From: [REDACTED]
Sent: 25 November 2025 10:40
To: Planning
Subject: Planning Application No:3/2025/0752

I am writing in regard to the above planning proposal.

PROPOSED GROUND FLOOR  
PLAN & VISUALS FOR TENDER  
PURPOSES

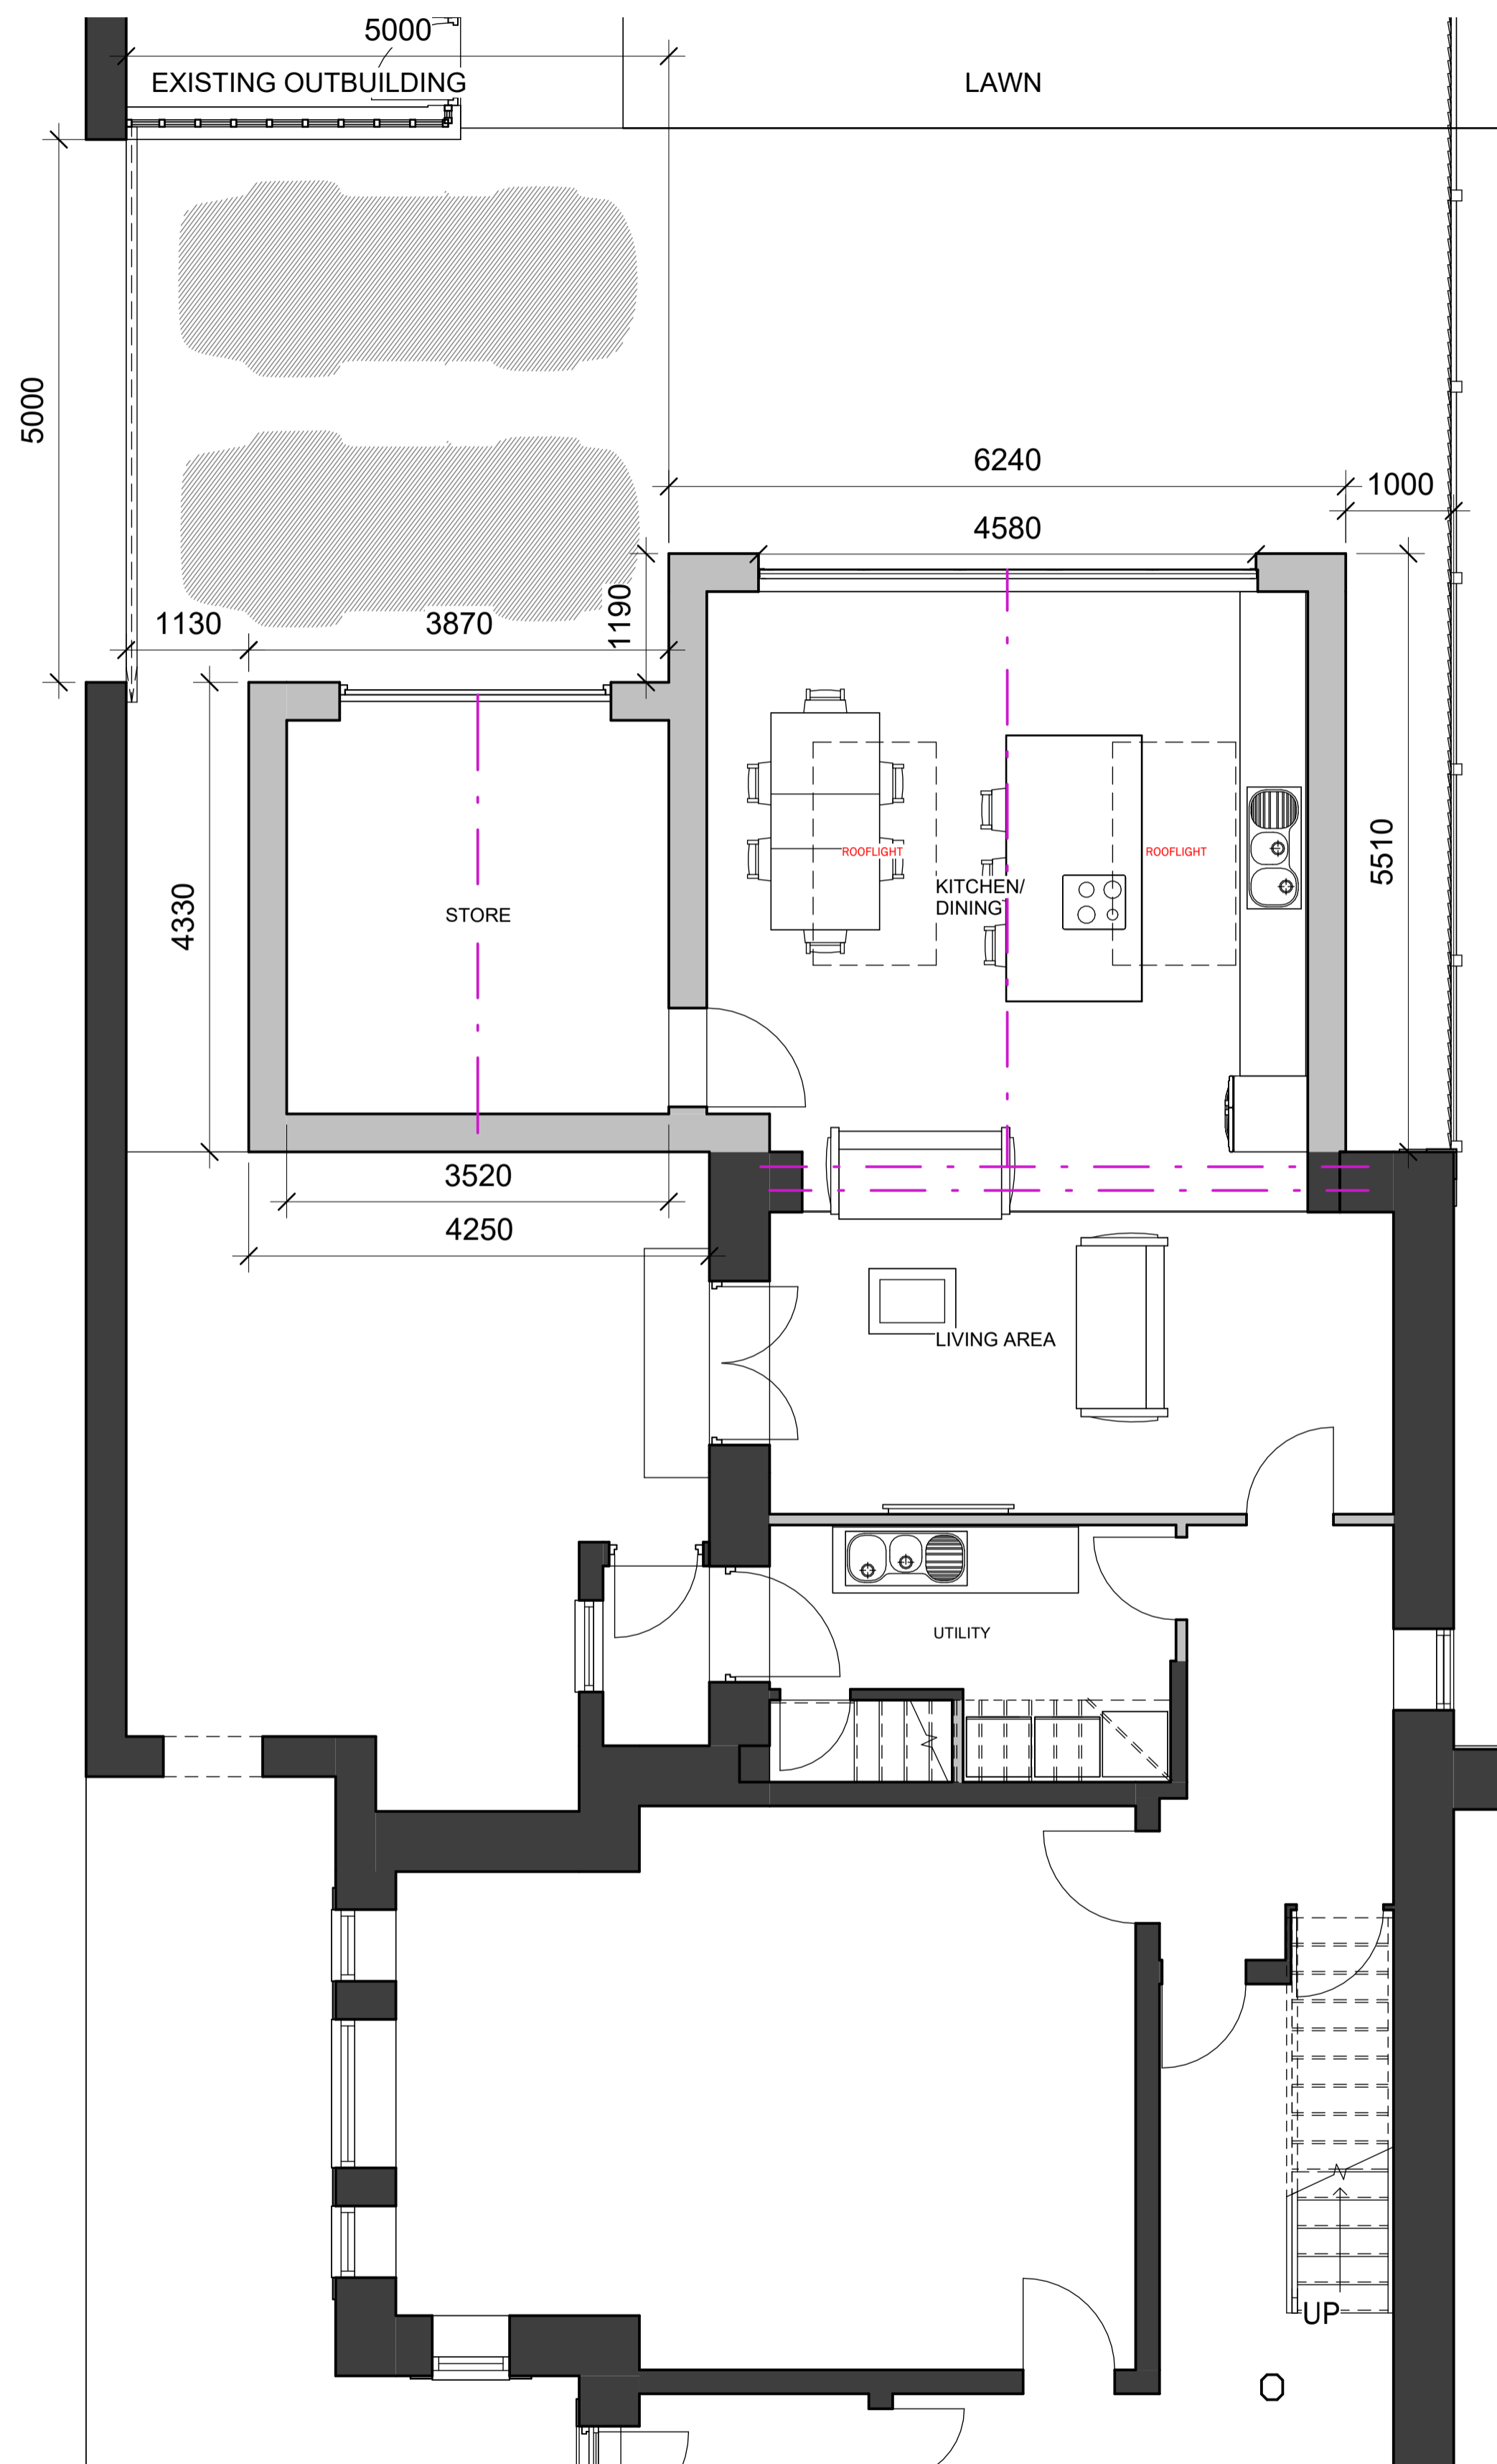
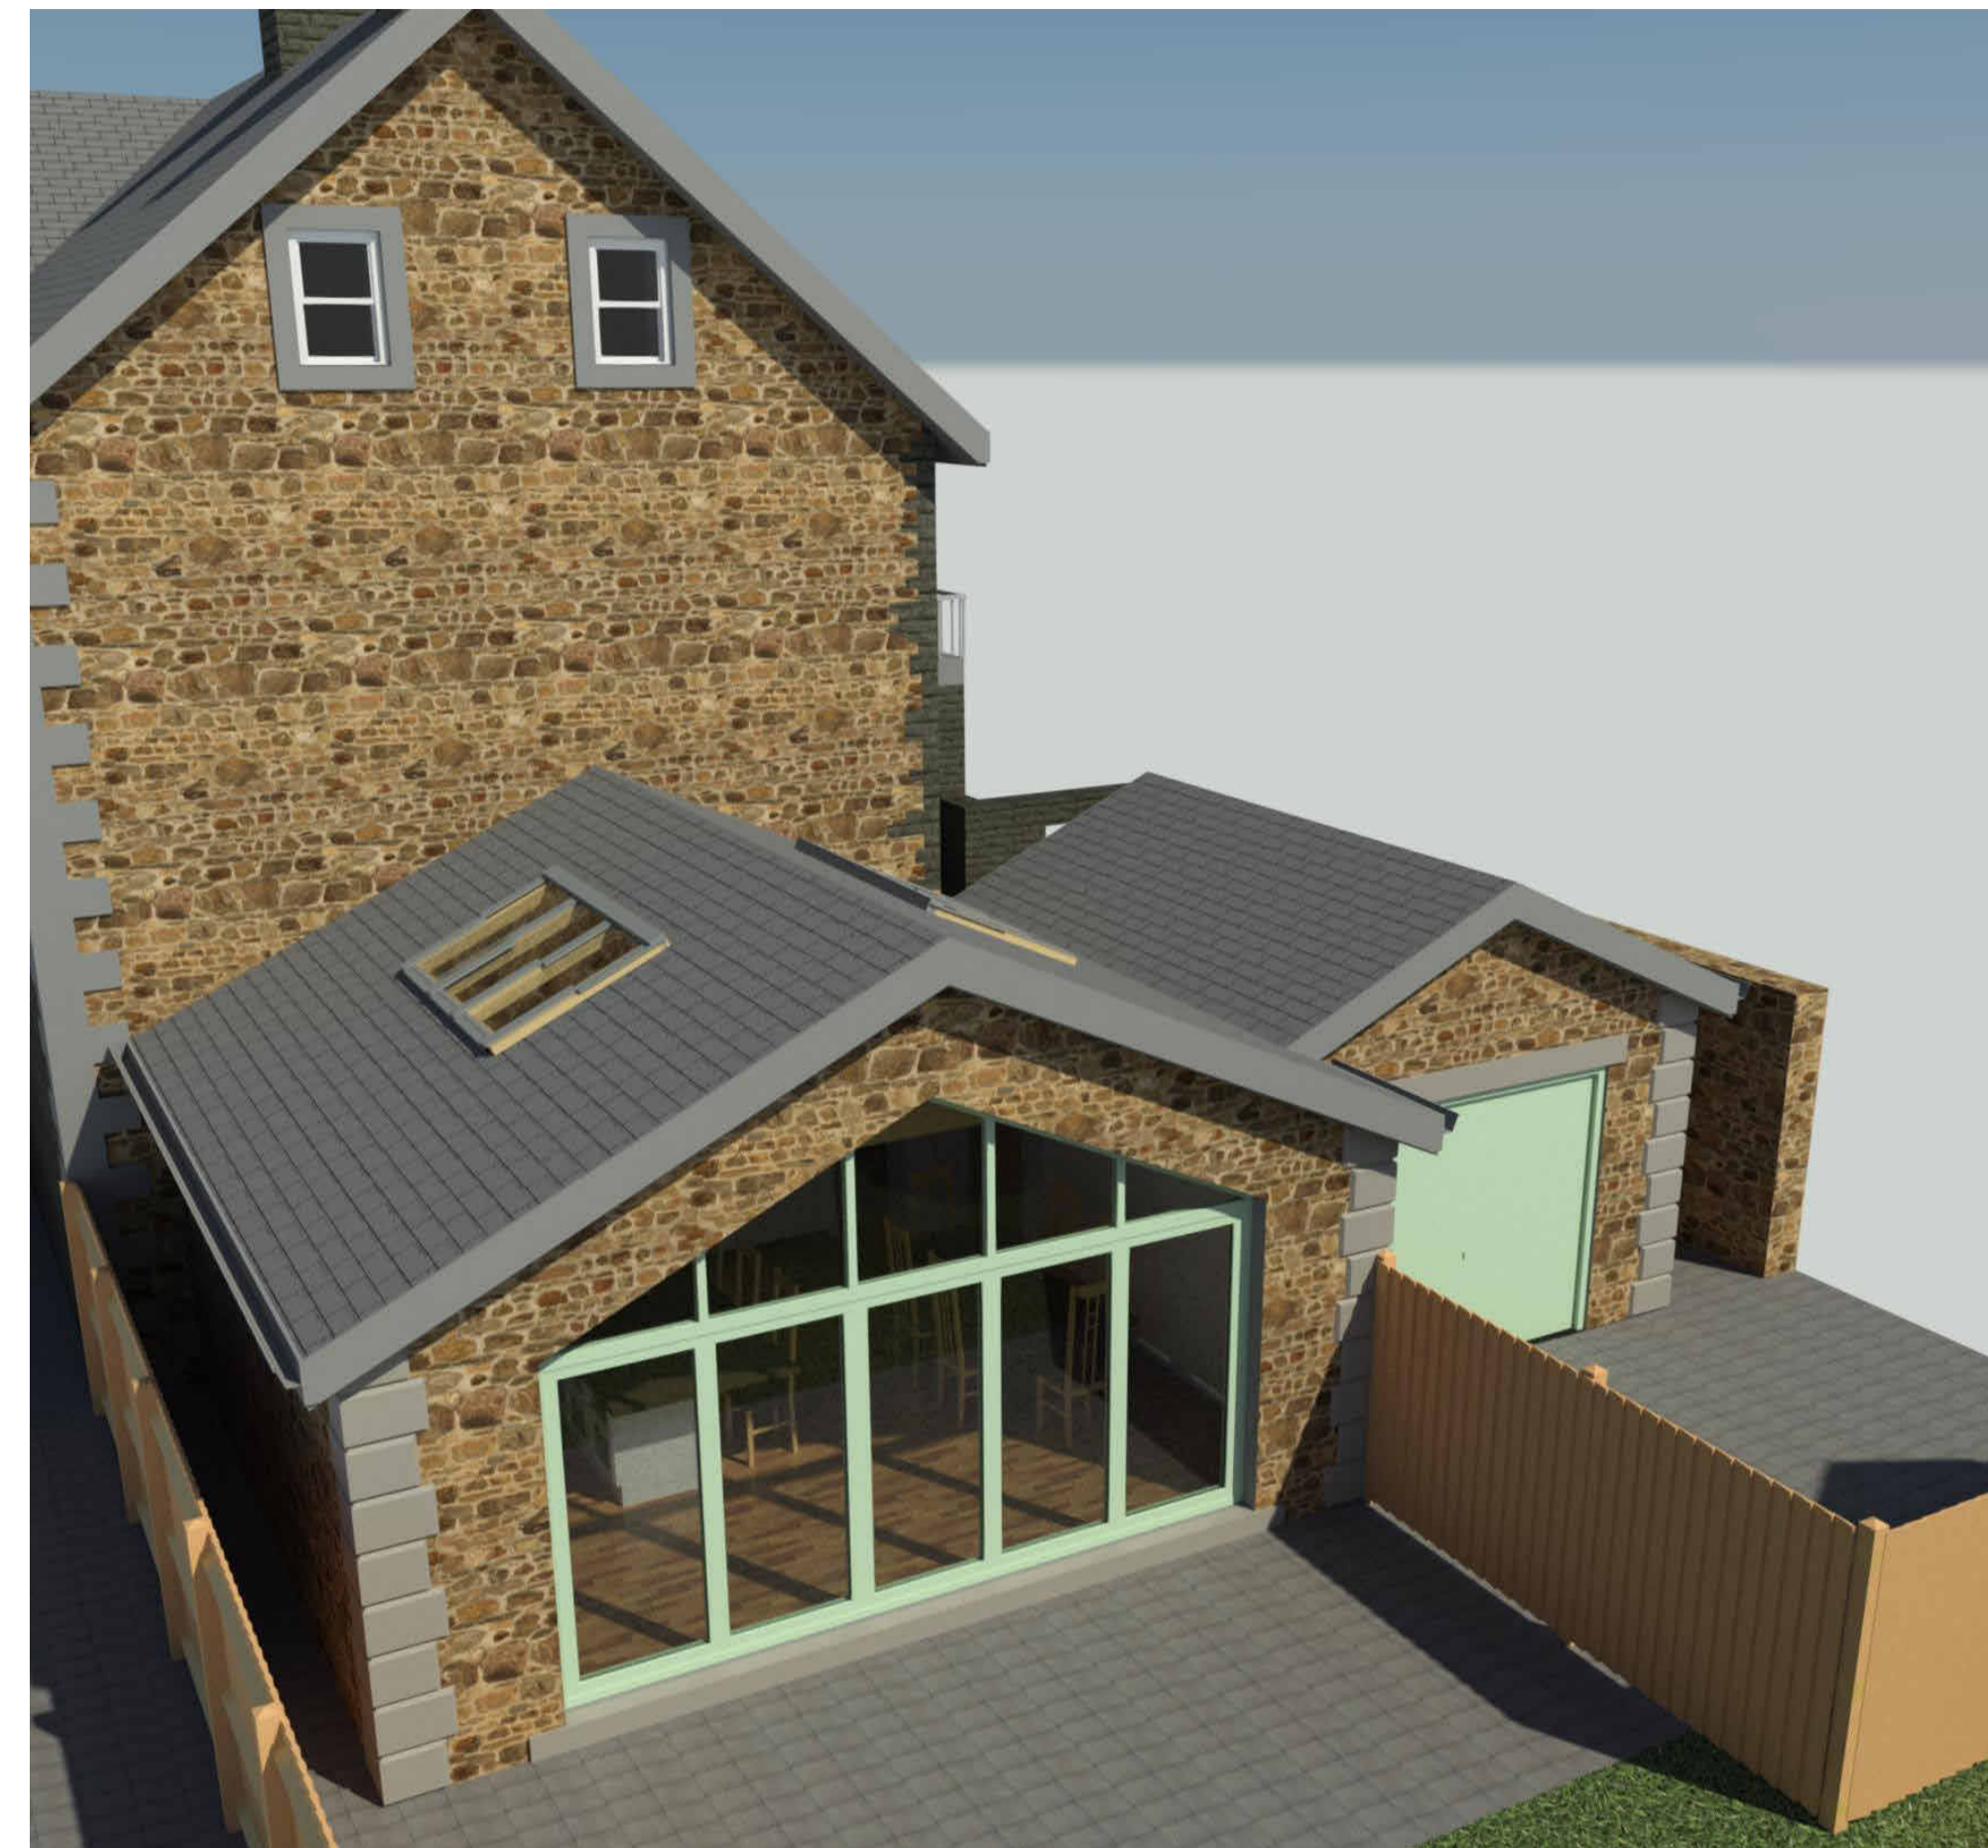
The outside wall of the proposed extension [REDACTED] and will block the [REDACTED] therefore impacting the quality of our family's domestic life. The absence of light will [REDACTED] absence of daylight. The encroaching [REDACTED] will be oppressive and will impact [REDACTED]

We have a further concern regarding the drain [REDACTED]. In the past, this drain has become blocked and [REDACTED] United Utilities have had to have access to it. Under the proposed plans, this drain will be built over.
